**Response to Submissions
Section 96(1A)
Modification Application
(MOD 2)**

Horsley Drive Business Park

Prepared by McKenzie Group Consulting Planning
on behalf of Australand Property Group
May 2015

Horsley Drive Business Park

NSW GOVERNMENT Planning

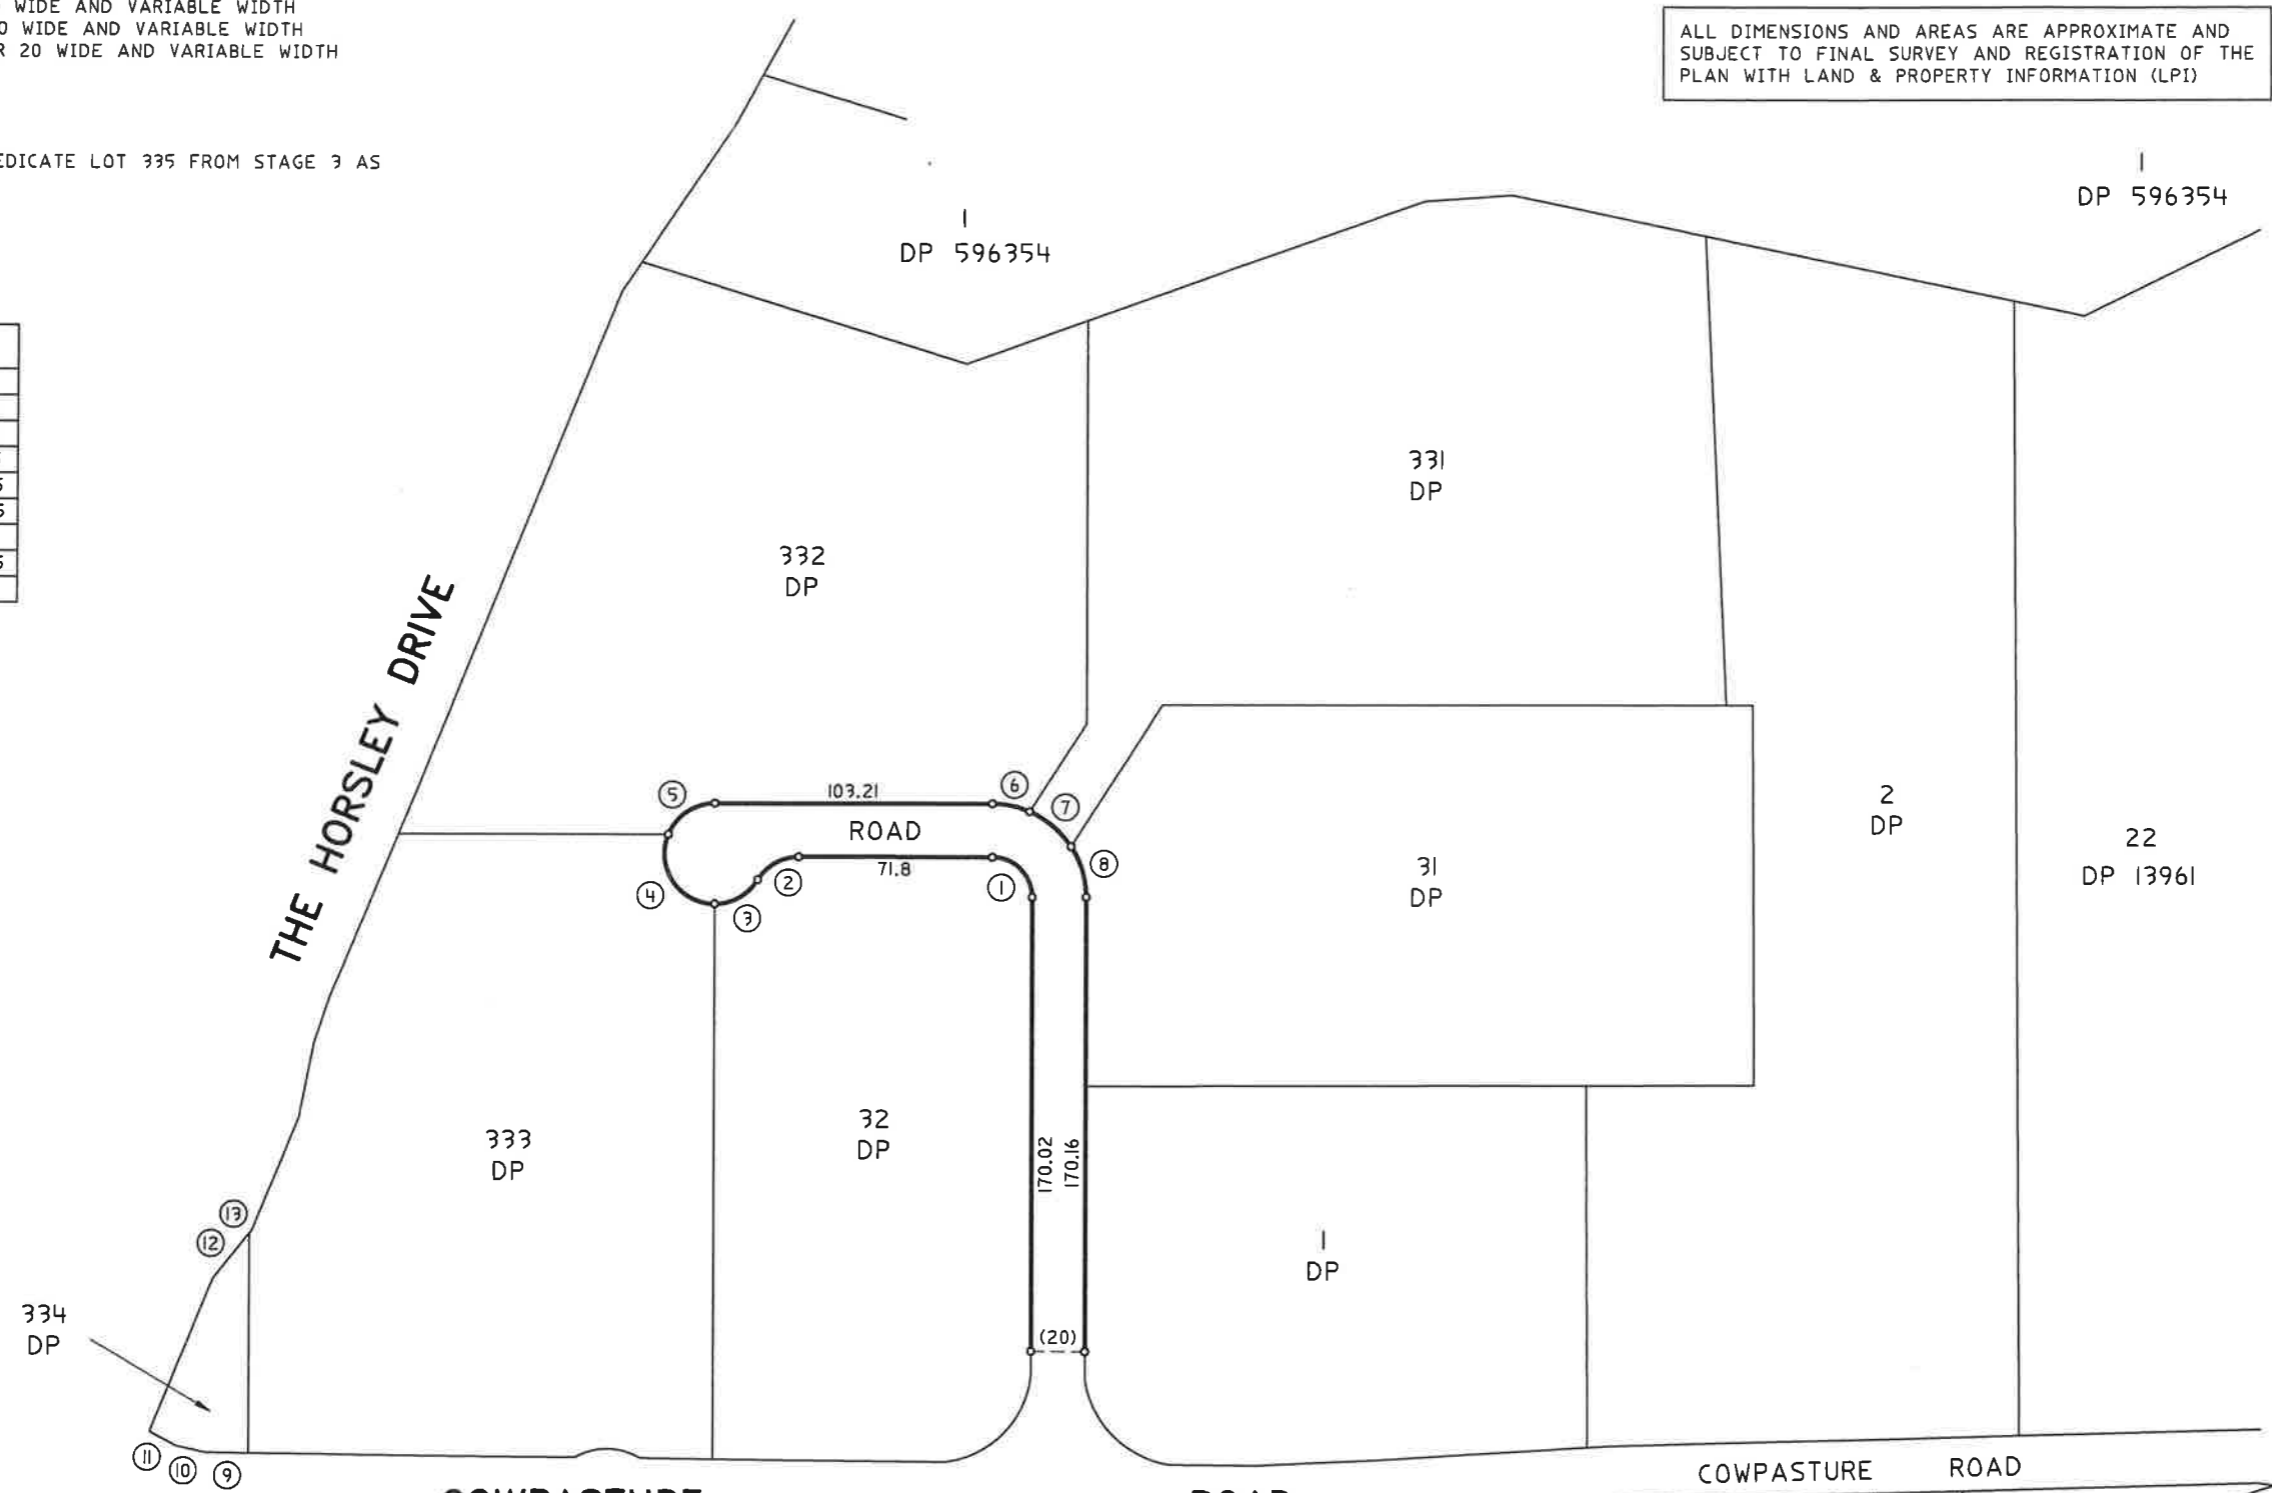
<p>3. Clarification of the Number of Stages</p> <p><i>The development consent provides for three stages. The Staging Plan, which accompanied the modification request dated February 2015, refers to 2 stages. However, the Draft Staged Plan of Subdivision in Appendix 4 of the modification request specifies that four stages are proposed.</i></p>	<p>It is now proposed to delete reference to staging of the Estate on Drawing MP-WSPT-FS-011. A revised Estate Masterplan is annexed to this submission (Appendix 3) which details such. The staging is still required for the Subdivision of the land; however this is not staged development as defined under the Act.</p> <p>For the purpose of issuing a subdivision certificate as a staged approach, the following condition is required.</p>

Table 1 – Submissions and Responses	
NSW Department of Planning & Environment	
Summary of Submission	Response
<p><i>Please clarify the number of stages involved in the proposed modification, together with the intent of proposed Condition D1A.</i></p>	<p><i>D1A. Approval is granted under this consent (SSD 5169 – MOD 1) to carry out subdivision and the works within the estate as a two phase process for each stage of the development:</i></p> <p><i>Phase 1 – Create residue lots and a lot for the road providing easements for services and right of carriageway (over 3 sub-stages).</i></p> <p><i>Phase 2 – Extinguishment the easement for services, right, of carriageway and dedication of the road as "public road" to Fairfield City Council, following the works construction.</i></p>
<p><i>4. Section 96 of the Environmental Planning & Assessment Act 1979</i></p> <p><i>The Department is concerned that the proposed modification would not have a minimal environmental impact as required under Section 96(1A). Please provide justification as to why the Department should assess the as a Section 96 modification Application.</i></p>	<p>As the modifications sought result in the development being substantially the same as that which consent was originally granted for, the provisions under Section 96(1A) of the Act apply. The following tests require consideration in this instance:</p> <p><i>A consent authority may, on application being made by the applicant or any other person entitled to act on a consent granted by the consent authority and subject to and in accordance with the regulations, modify the consent if:</i></p> <p><i>(a) it is satisfied that the proposed modification is of minimal environmental impact</i></p> <p>The proposed development (as amended) shall result in minimal environmental impact on surrounding properties. On balance, the proposal is considered to satisfy this test for the following reasons:</p> <ul style="list-style-type: none"> ▪ Traffic generation rates are generally consistent with that approved under the parent approval being SSD 5169;
